Memorandum

Date: October 18, 2013

Re: **October 22nd Planning Board Workshop**
Level III Site Plan and Subdivision:
Munjoy Heights
29 unit condominium, 79 Walnut Street
Jonathan Culley, Redfern Munjoy LLC

UTILITY PLAN
 MUNJOY HEIGHTS
 REDFERN PROPERTIES, LLC
 CLIENT: P.O. BOX 8816, PORTLAND, MAINE 04104

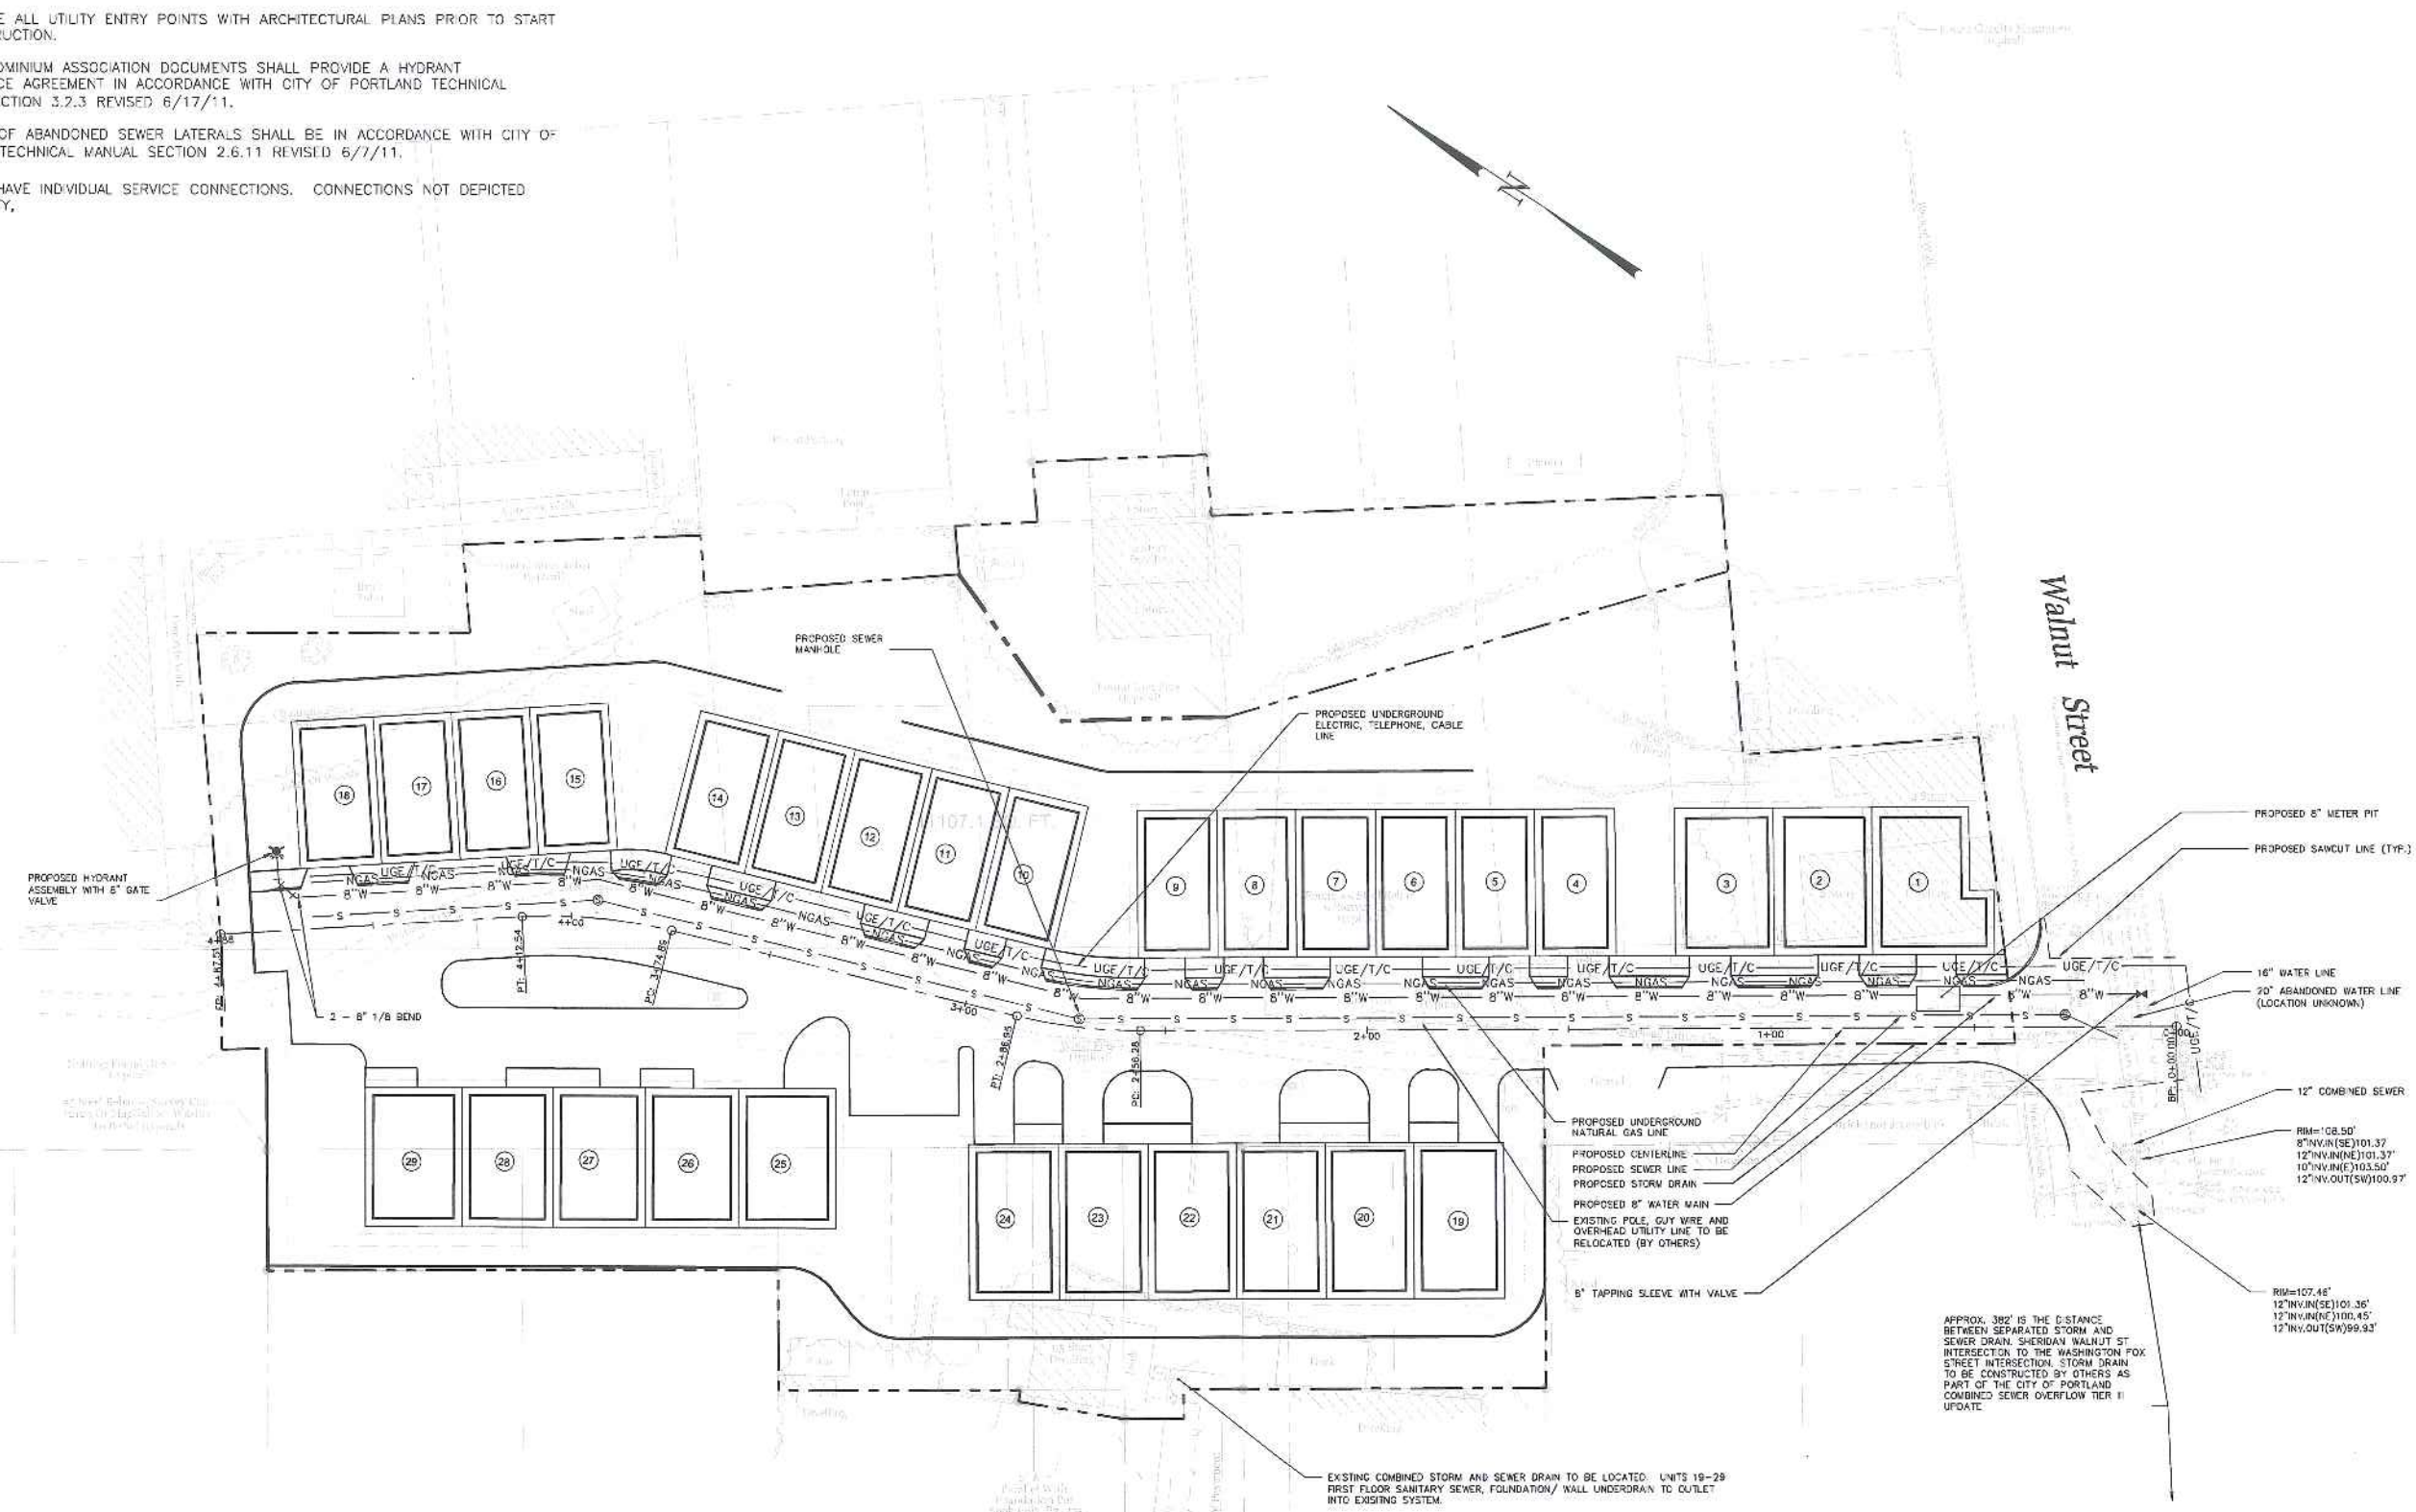
The applicant has submitted a Utility Plan (Plan 7) and DPS have noted that “*Plan details, plan /profile showing invert elevations, pipe size/material and slopes will be required for the proposed stormwater and sanitary sewers.*” (Attachment 7).
